Kariong Sand and Soil Supplies Facility (SSD 8660)

The proposal seeks approval for expansion and upgrade of an existing resource recovery facility located at 90 Gindurra Road, Kariong (Lot 4 DP 227279). Clarification is sought on the use of B-Double access as outlined below.

CD19/01052

19 m SEMI TURNING PATHS PLAN

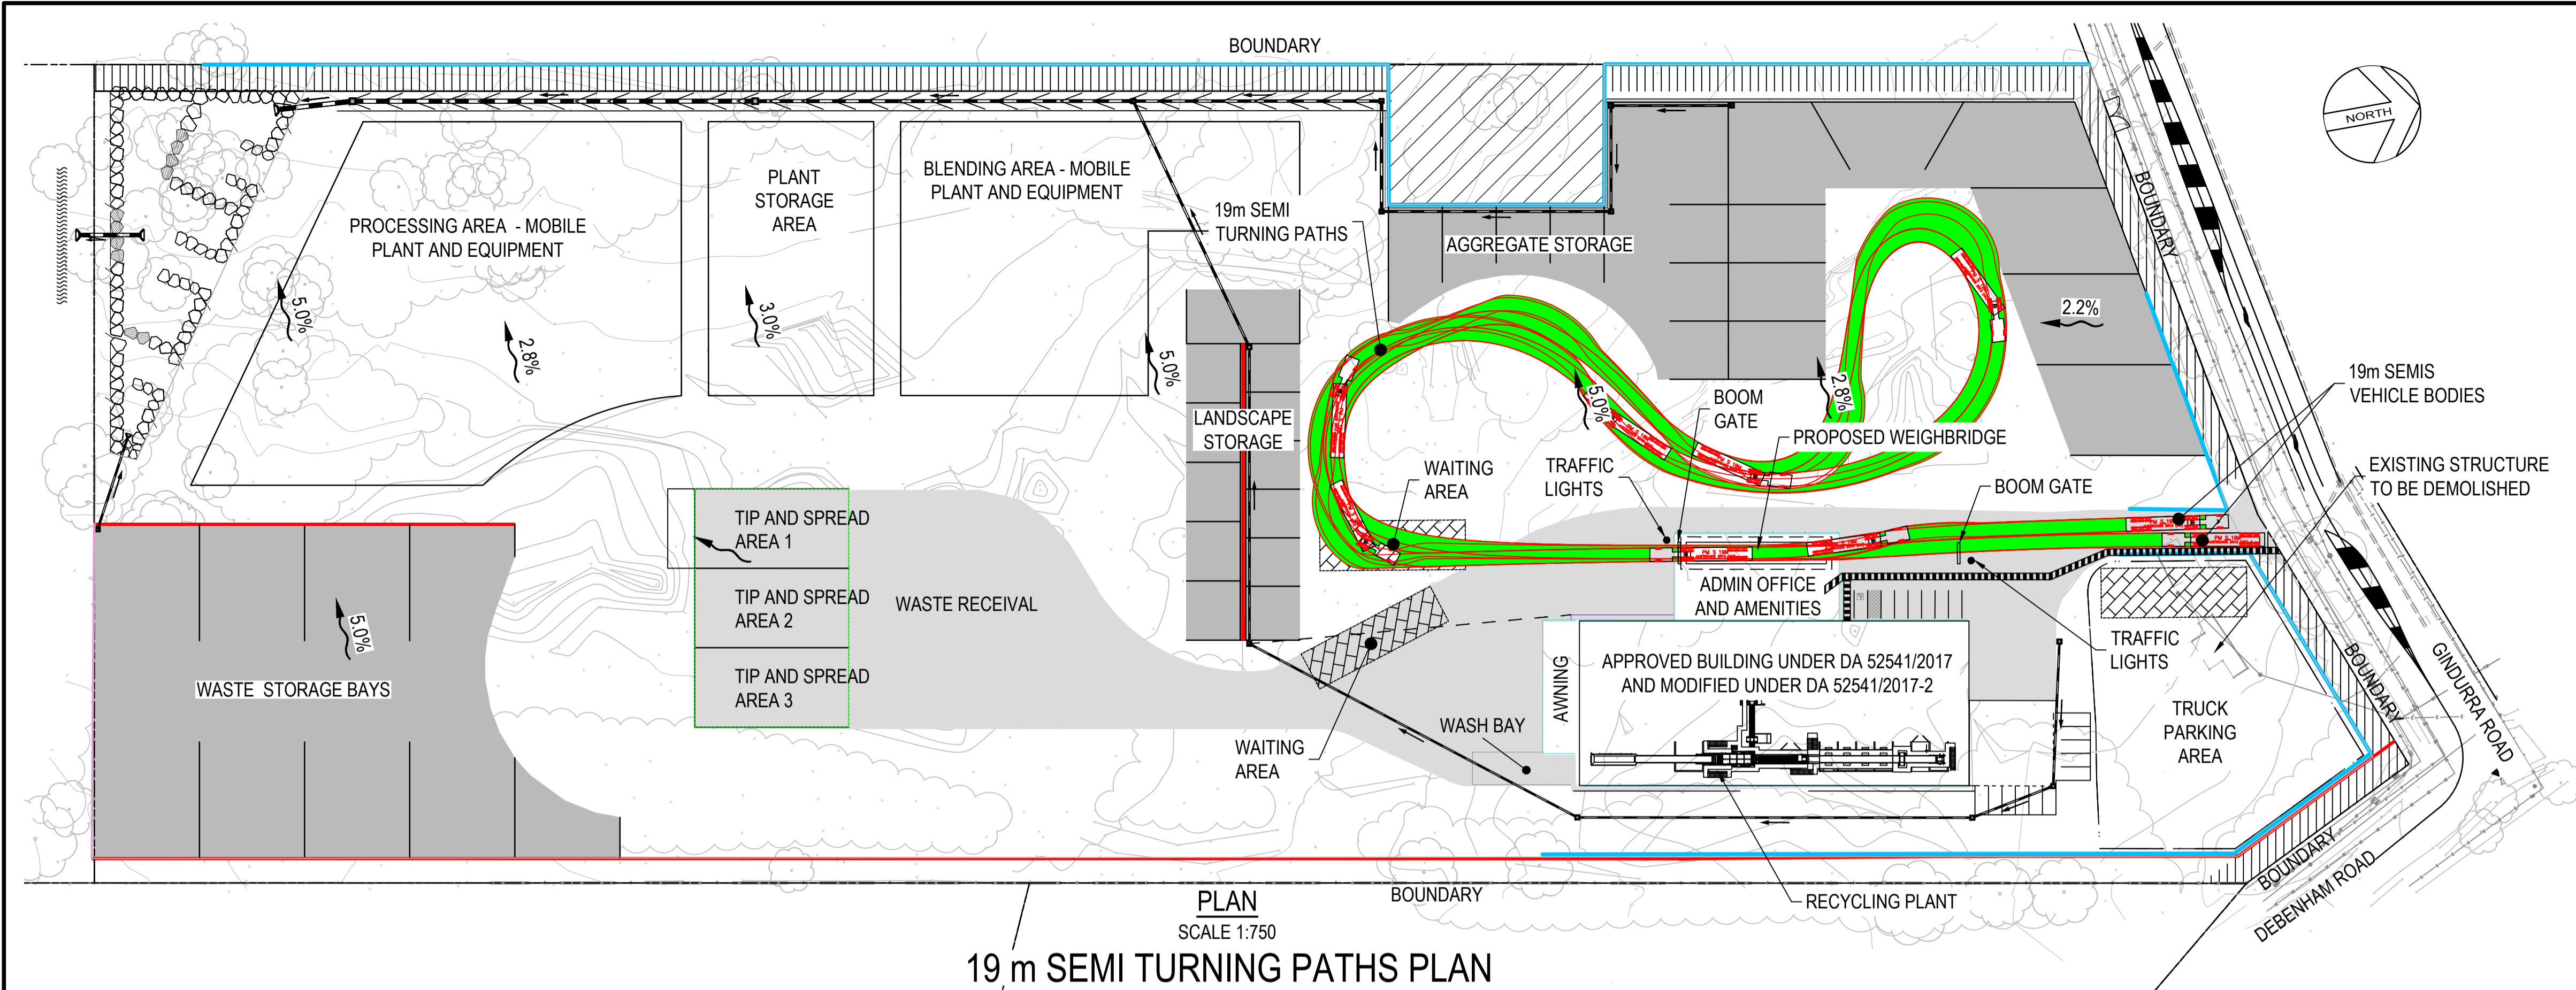
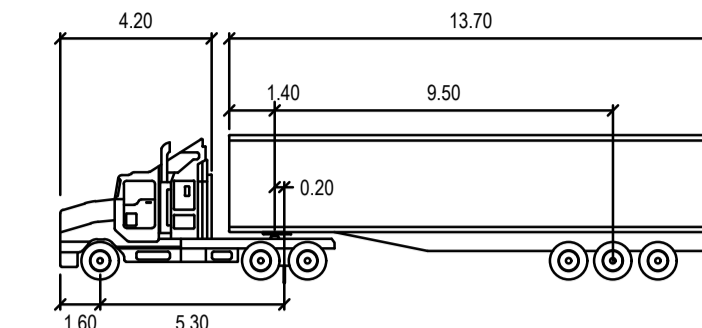
Swept path analysis should also be provided for semi-trailers.

26 m B-DOUBLE TURNING PATHS PLAN

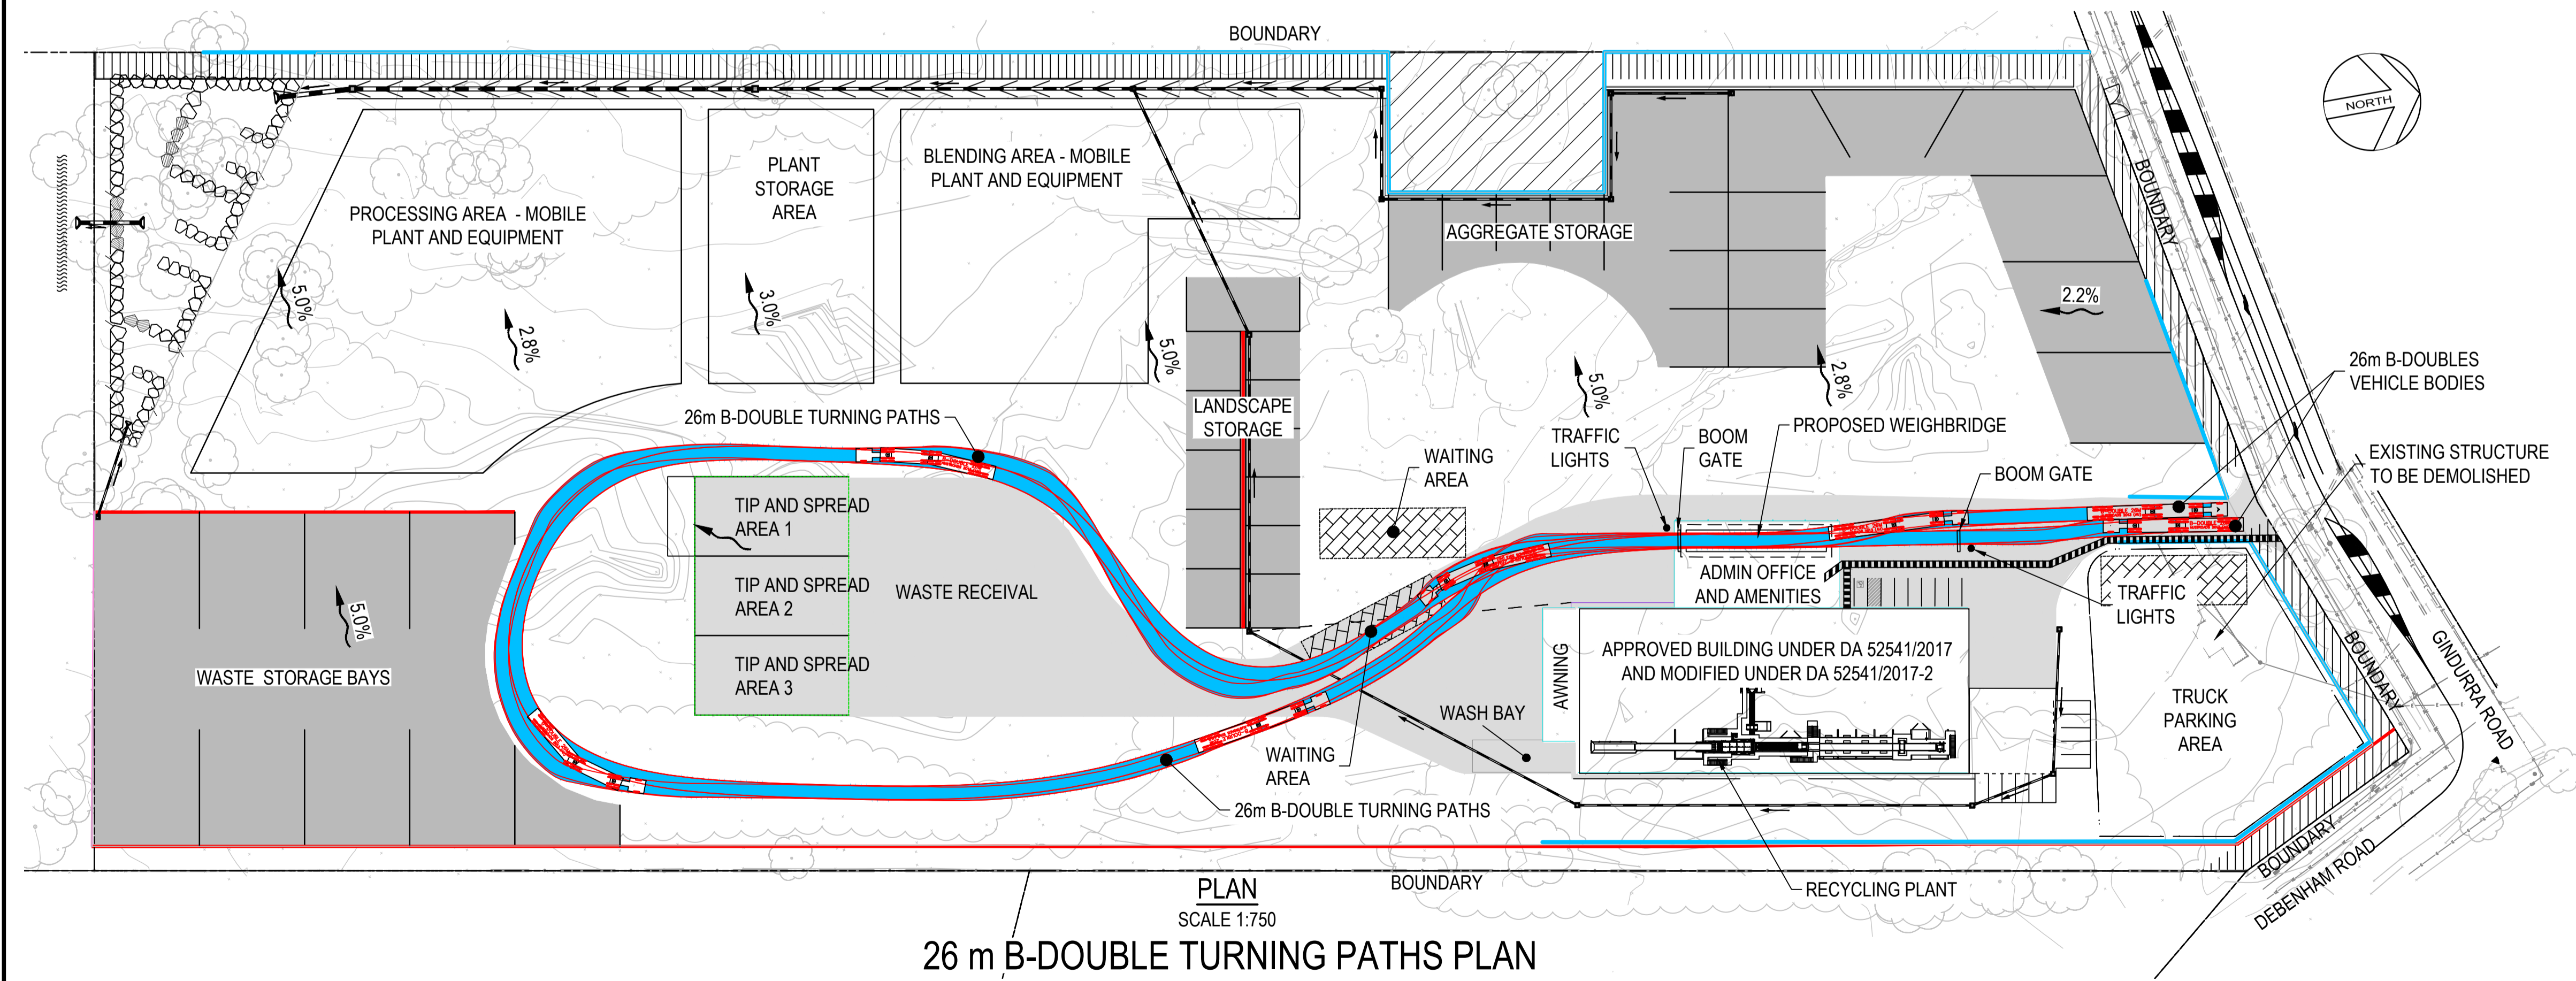
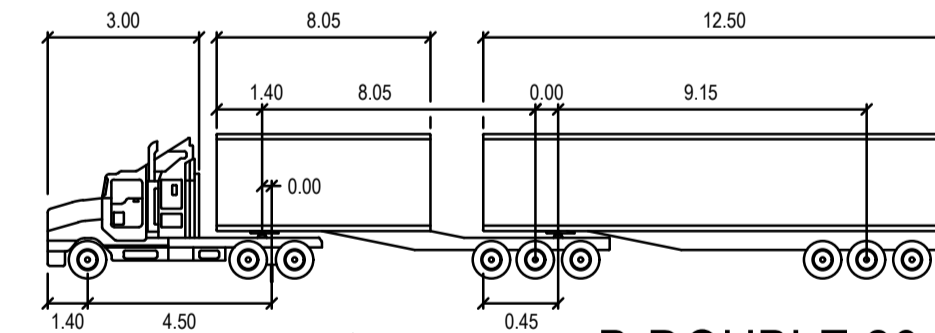
The proposal states that the proposed heavy vehicles servicing the site will include tippers, truck and dog or semi-trailers and B-doubles.

Gindurra Road is not currently identified as a B-double route (neither 19m B-double over 50t, nor 25/26m B-doubles) on the RMS RAV map. Swept path diagrams for a 25m B-double are presented in the traffic report.

The use of smaller vehicles with smaller payloads would increase the number of heavy vehicles required for the freight task.

Clarification should be provided to address the apparent discrepancy and assess the impact if there would be an increase of heavy vehicle movements.
